Our Case Number: ABP-314724-22

Re: Railway (Metrolink - Estuary to Charlemont via Dublin Airport) Order [2022]
Metrolink. Estuary through Swords, Dublin Airport, Ballymun, Glasnevin and City Centre to
Charlemont, Co. Dublin

Case: 314724: Estuary through Swords, Dublin Airport, Ballymun, Glasnevin and City Centre to Charlemont, Co. Dublin (Metrolink)

Observation

Project	Drawing Title	Drawing Status
Estuary - Seatown Landscape Layout Preliminary Design Issue		S4
Drawing N°	ML1-JAI-ARL-SC01_XX-DR-Y-00001	
Scales Original Size A1	1:1000	Sheet 1 of 3

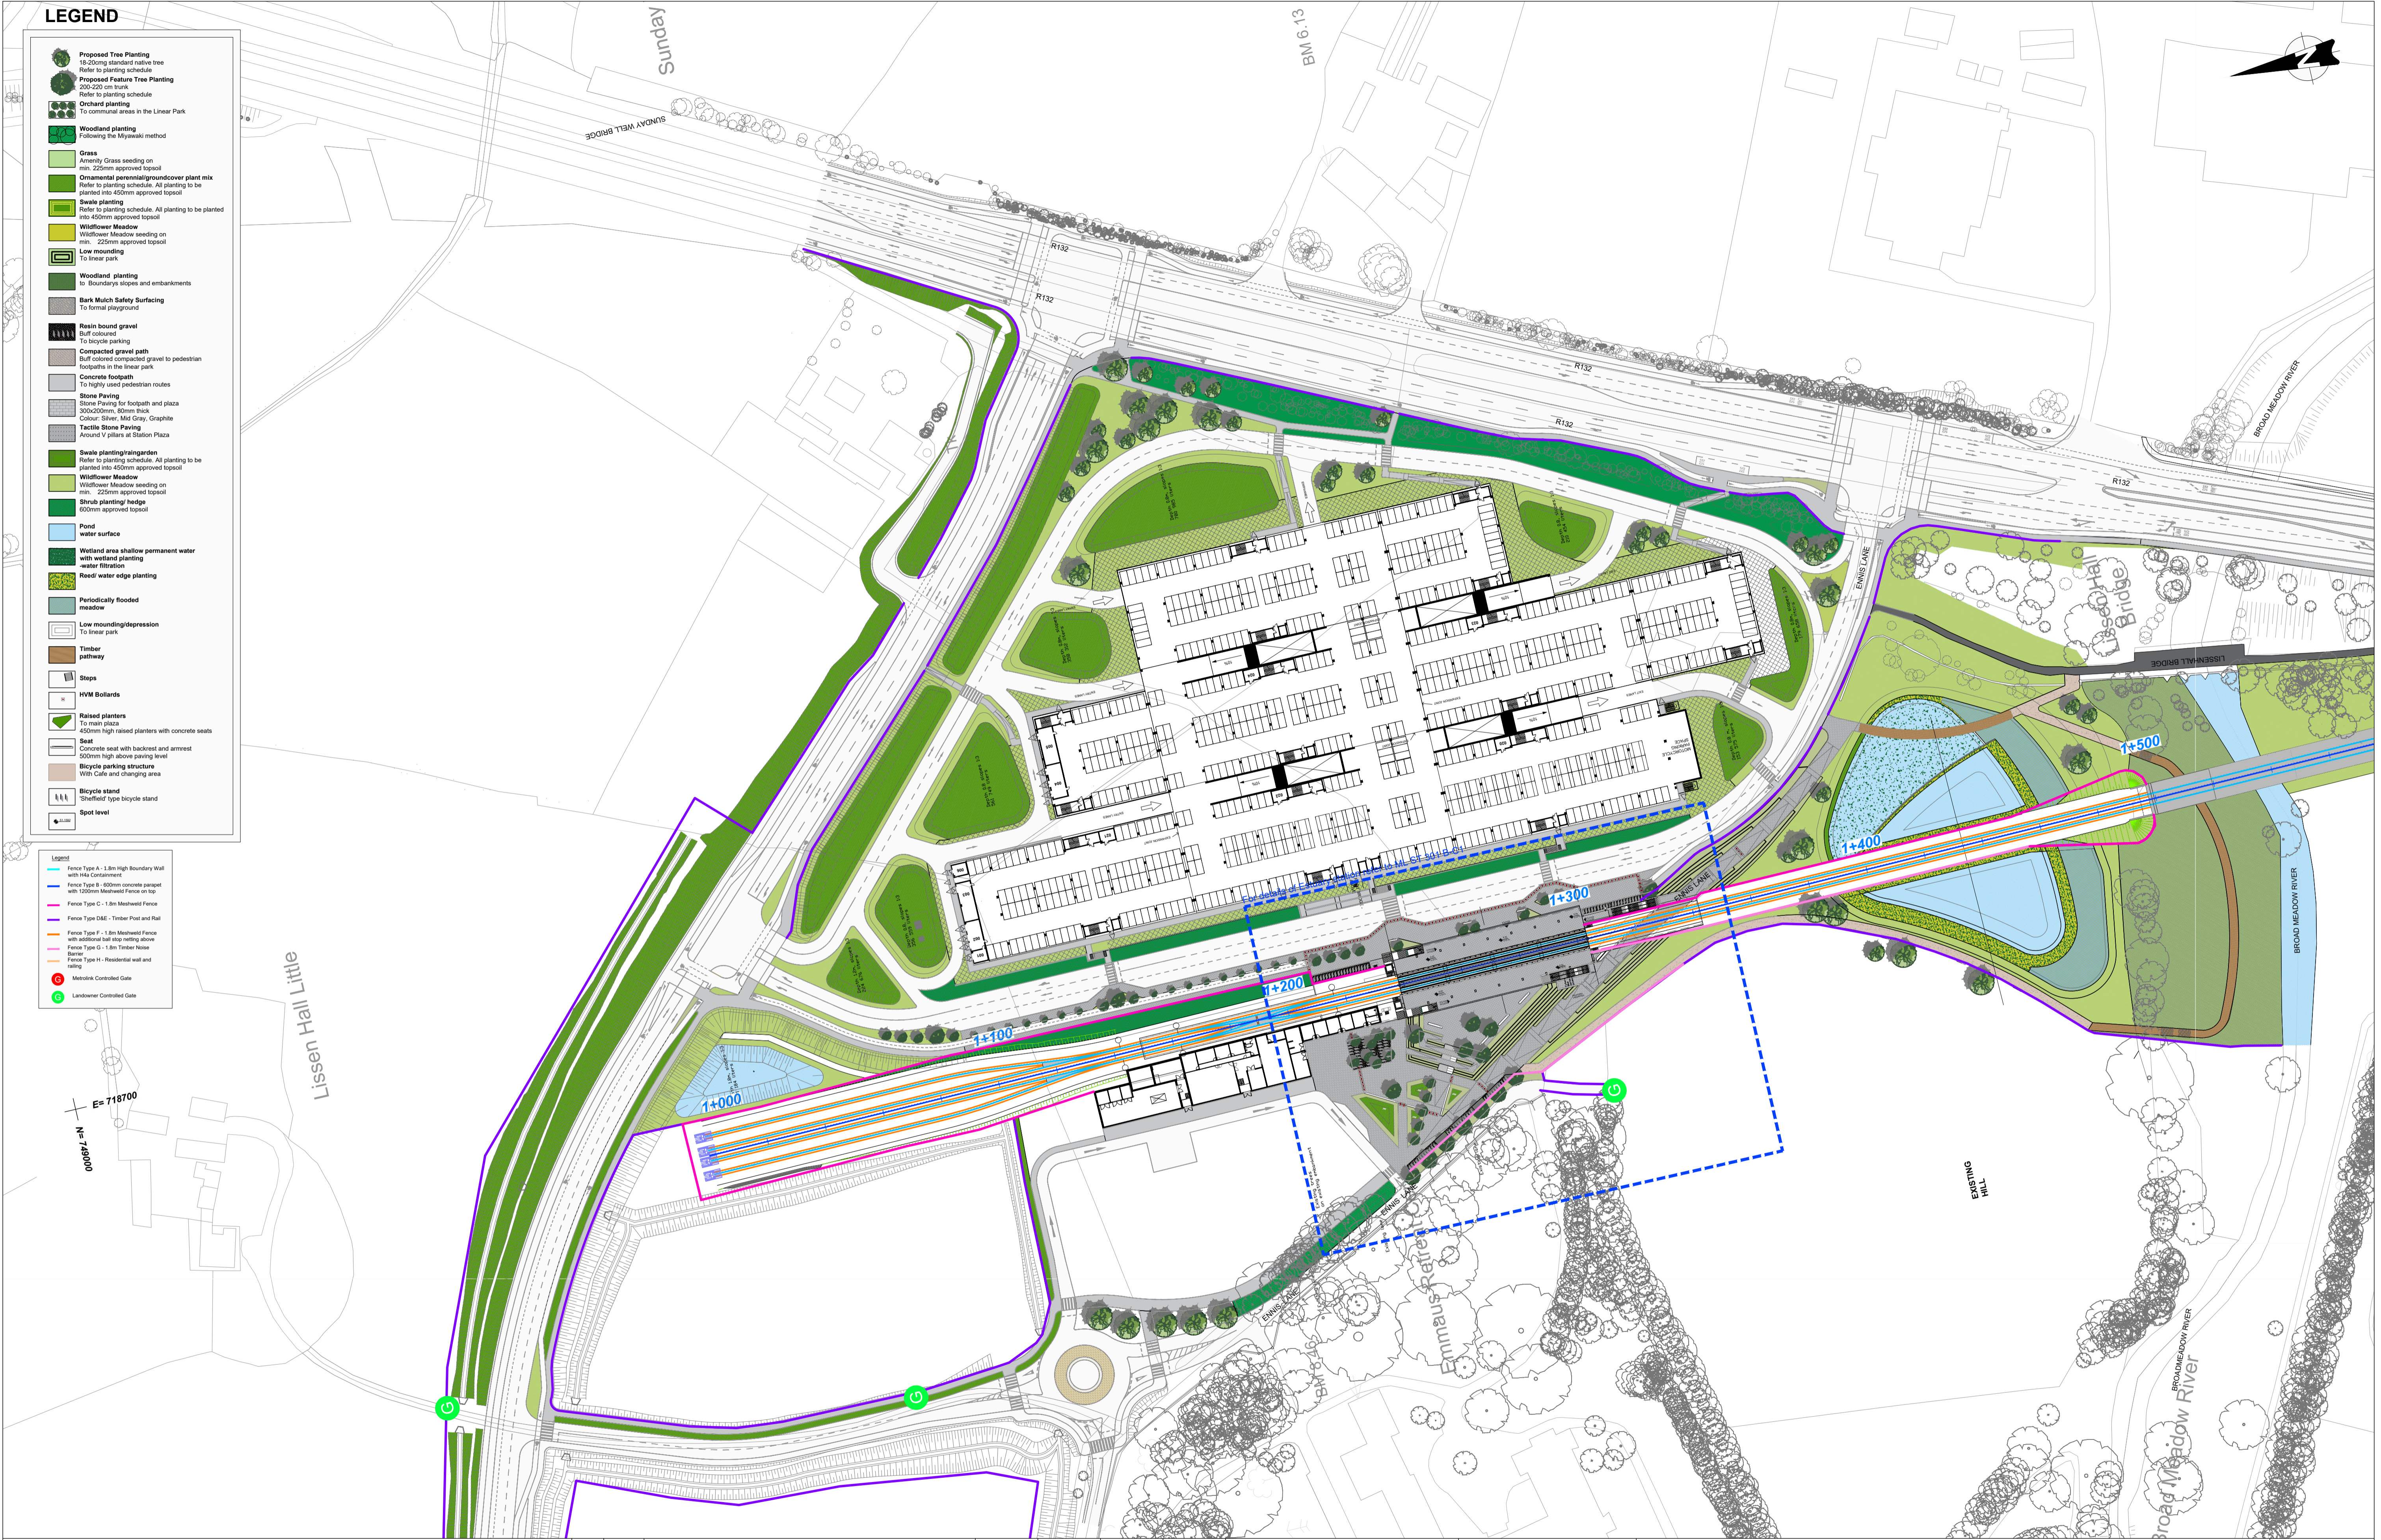
Description: Construct new pathways with associated landscaping and a signalised pedestrian crossing of the R132 and on land adjacent to R132 connecting Estuary Court & Seatown Villas as shown on Plan No. ML-RO 301 H-J.

Observation Comments: The existing vehicle and pedestrian access to Estuary Court meets the access requirements of the residents of Estuary Court. Removing the existing boundary wall to creating new pathways into Estuary Court from the R132 does not fulfil any access gaps or requirements. It also creates a unsafe zone for children of the Estuary Court estate because the children would have direct access to the dual carriageway from the only estate green area. It also creates an unsafe area along

the R132 for cyclists, pedestrians and vehicles as young children and children's toys (e.g. footballs) may travel at speed out onto the R132 without any warning. Reinstating the existing wall without adding unnecessary additional entrances to the Estuary Court would remove this liability and greatly enhance the life of the residents of Estuary Court.
